DESIGN PROFESSIONAL INSPECTION FORM

Residential Single-Family Project: ☒ Y ☐ N	Commercial Project: ☐ Y ☐ N
Code Enforcement Project No: <u>SFD2503-0122</u>	Permit No:
Project Name: <u>WILLIAM H. CLARK HOUS</u>	Owner:
Project Address: <u>35 TORREY CT, ANGIER</u>	Suite No:
Date Inspected: <u>9/23/2025</u>	Contractor Name:
Component Inspected: <u>FOOTER + FOUNDATION WALLS</u>

23 September 2025

Re: Changes to Footers and Foundation Walls
35 Tori Vic Court
Angier, NC 27501

1 FOUNDATION PLAN
1/4" = 1'-0"

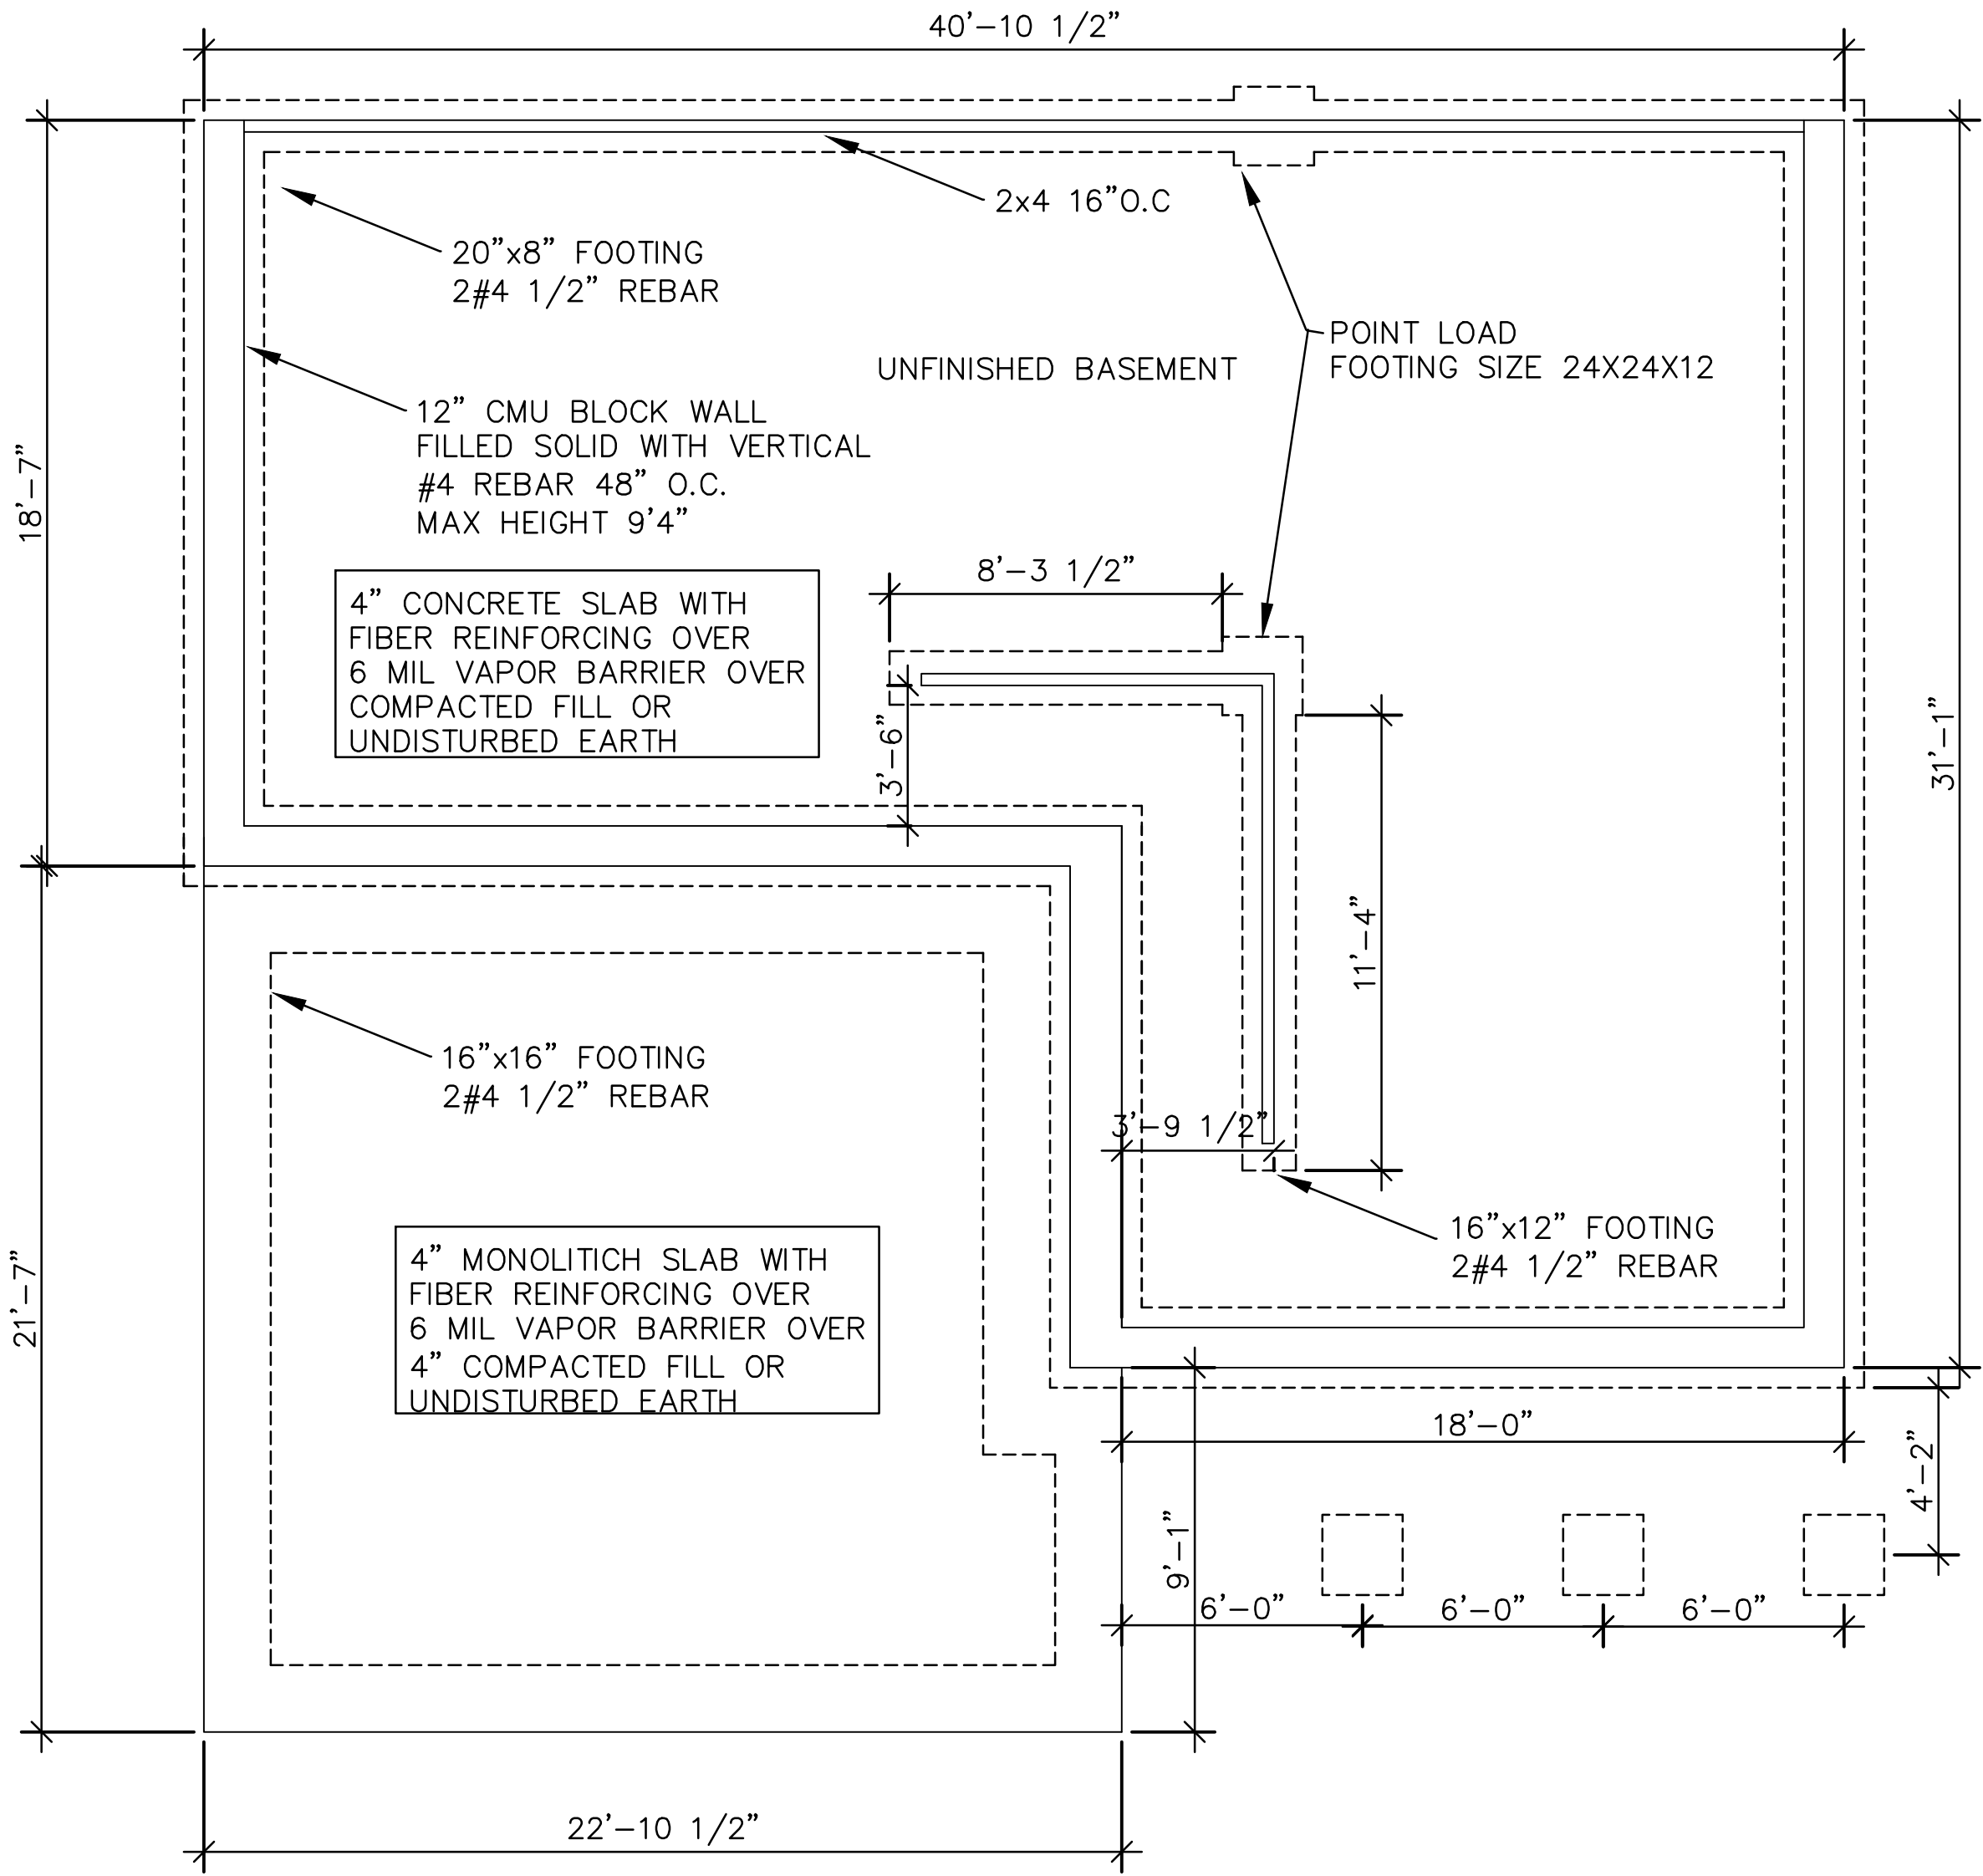
- 1) Construct a new footer at the front of the garage so that it connects to the existing footers for both sides of the walls forming the garage. Since the footers are discontinuous, drill the existing footer on both sides of the garage and insert 2 #4 rebars with epoxy mid-point into each footer. Pour a new same size garage connecting the existing footers to the new footer making all footers continuous.
- 2) The tall foundation walls will require additional support. Use 12" concrete block to construct the walls. Provide 1 #4 rebar vertical reinforcing every 4' along the wall. As the wall is built higher, add ladder wire along the entire length of blocks on alternate rows. Finish the wall by constructing a bond beam at the top using two #4 rebar and pouring the blocks solid.
